From: MIKE MURRAY [REDACTED]
Sent: 21 June 2018 07:45
To: Planning.Responses
Subject: Re: Please find attached details of Planning decision on Application Ref: FG/42/18/HH

APPLICATION FG/42/18/HH
NO:

Site 17 Foamcourt Waye Ferring BN12 5RD
Address:

Description of Works: Demolition of existing detached garage & rear conservatory, enlargement of existing driveway, single storey side extensions, extension of existing roof over proposed extensions with 5 No. dormer windows.

PROPOSED SITE PLAN

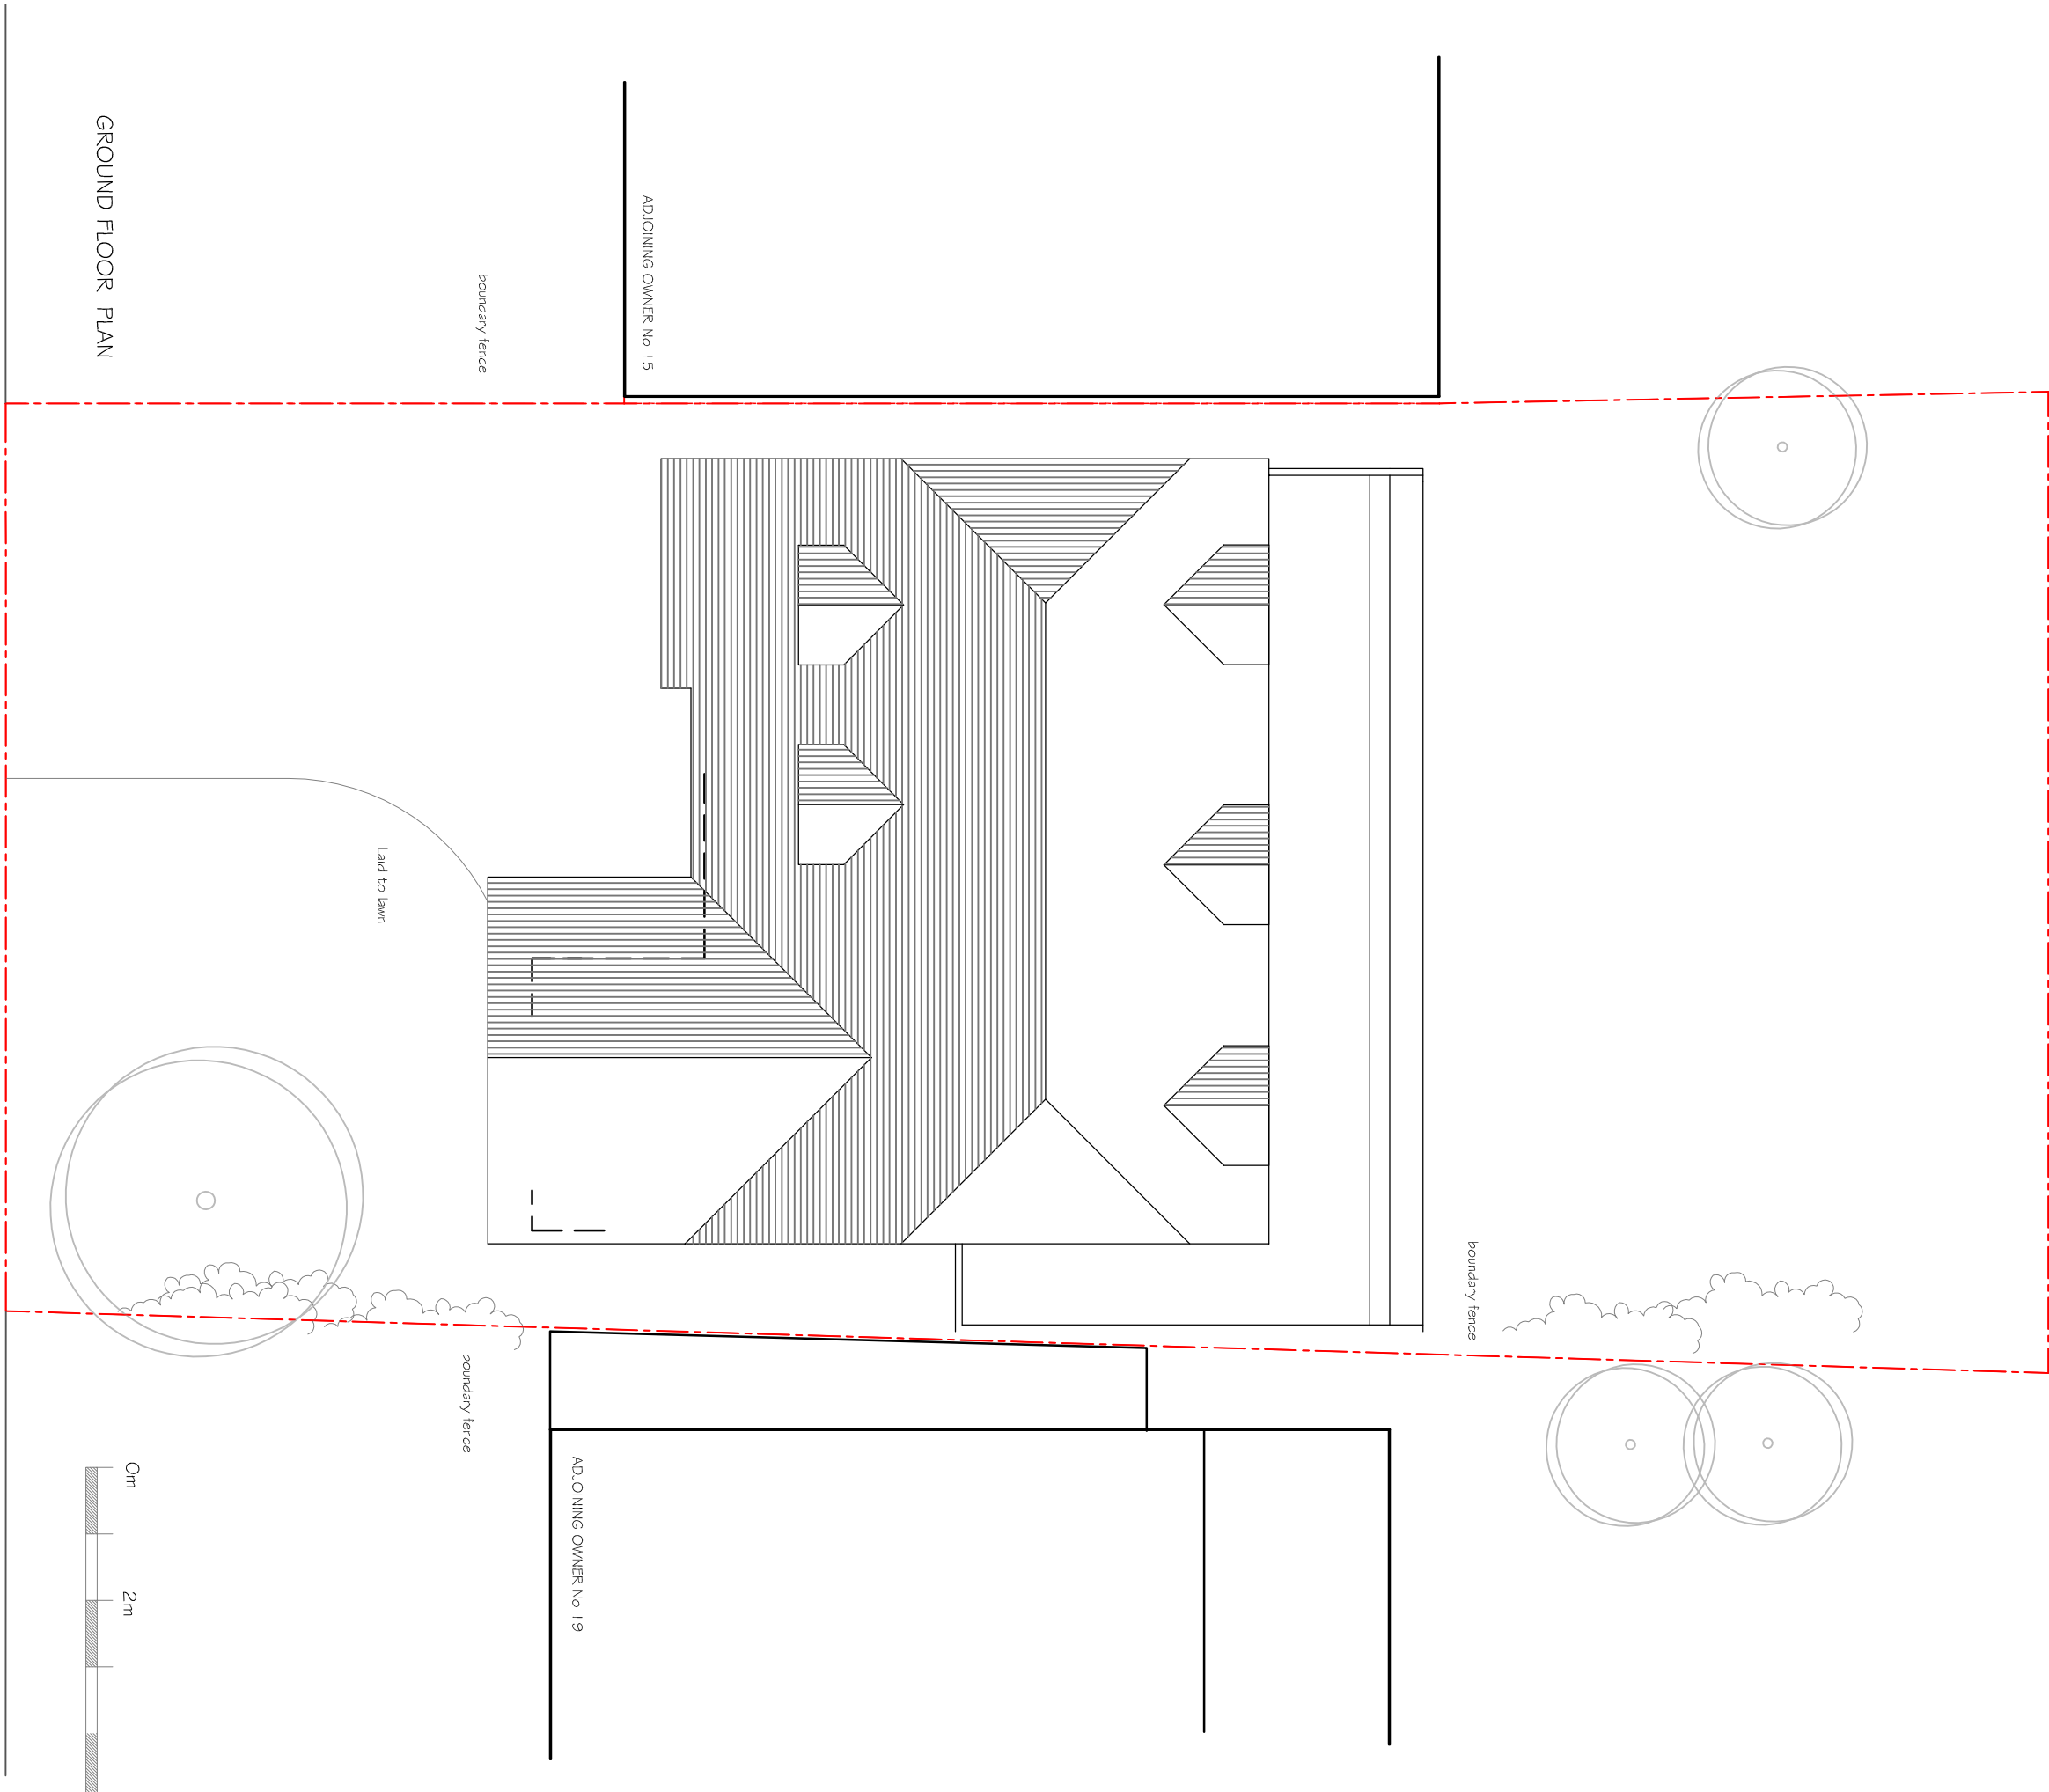
The stand out comment, is the Highways and Parking paragraph, first there are 4 spaces, then there is not, then there is neutral impact. It was pointed out that the vehicles on the plans were in miniature form to make out the space was larger and to confuse, clearly that has worked. Simply 4 vehicles cannot fit on the space shown, it is a case of deception. What else has been missed?
